**Consultation Response from KC,
Trees****2024/91425 2, Kaffir Road, Edgerton, Huddersfield, HD2 2AN****Erection of extensions and alterations (within a Conservation Area)****Date Responded: 10/10/2024****Responding Officer: JD****Responding Ref: HU1/71**

1 Site as Proposed
1 : 100

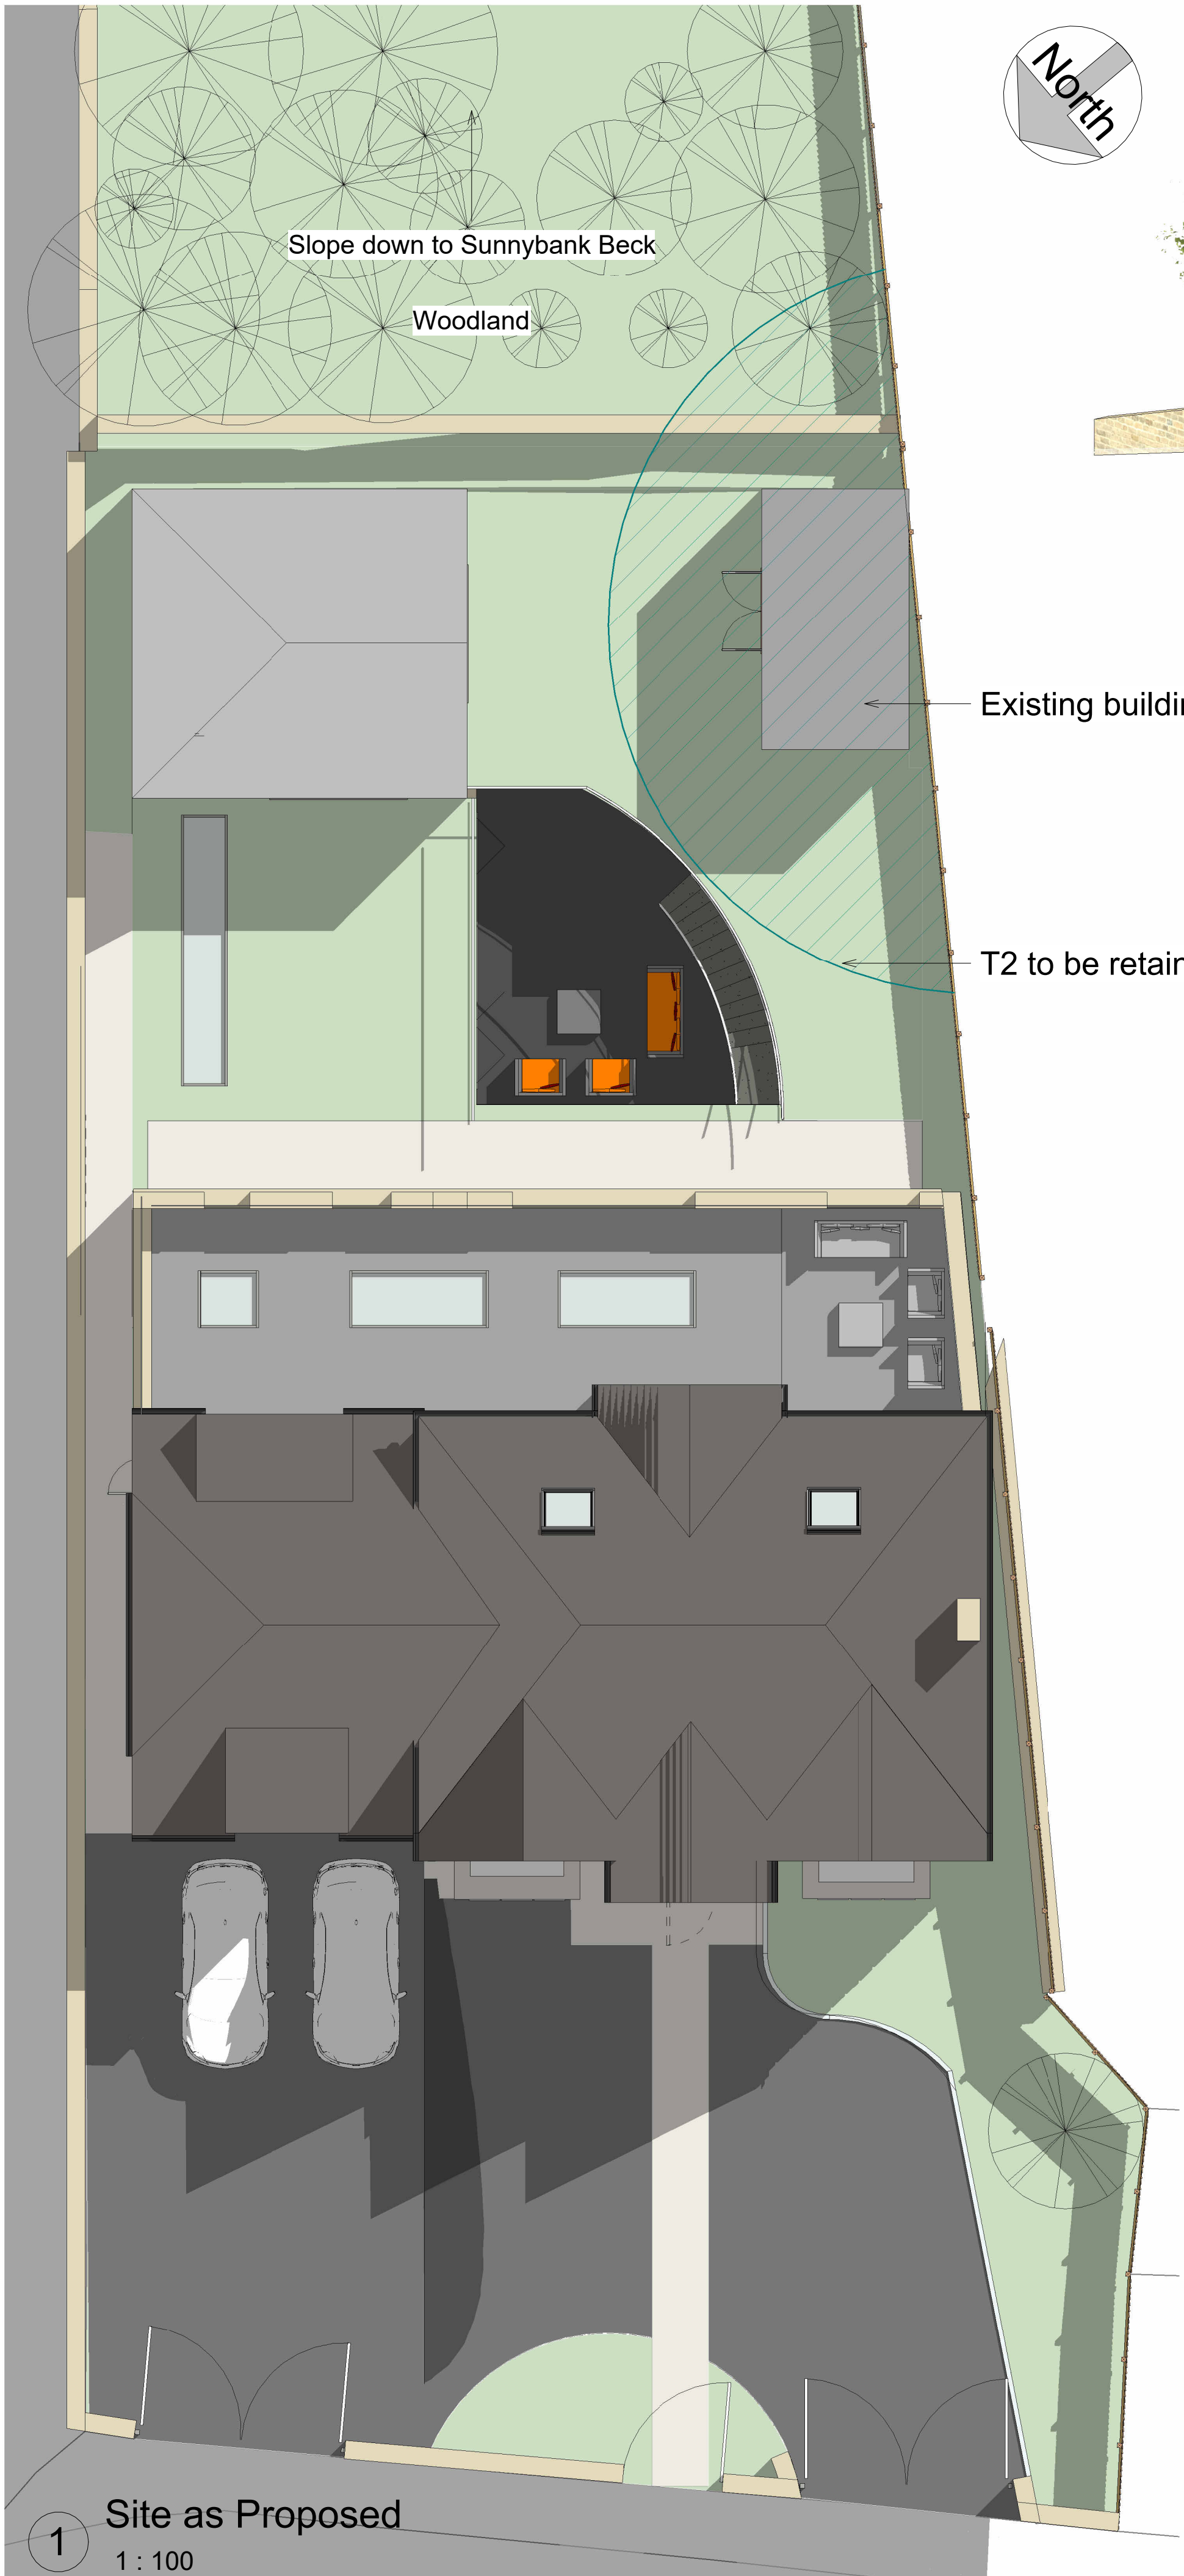
There is only one tree down for removal to facilitate the development which is not protected by a TPO but is protected under the conservation area. This removal would be deemed acceptable due to the tree being of low value.

The submitted plans are outside of root protection areas and therefore there would be no direct impact. There may be indirect impact due to increased pressure to prune or remove T2 due to shading but this can be controlled through application in the future.

A detailed arboricultural method statement is submitted and agreed with the council prior to any work commencing.
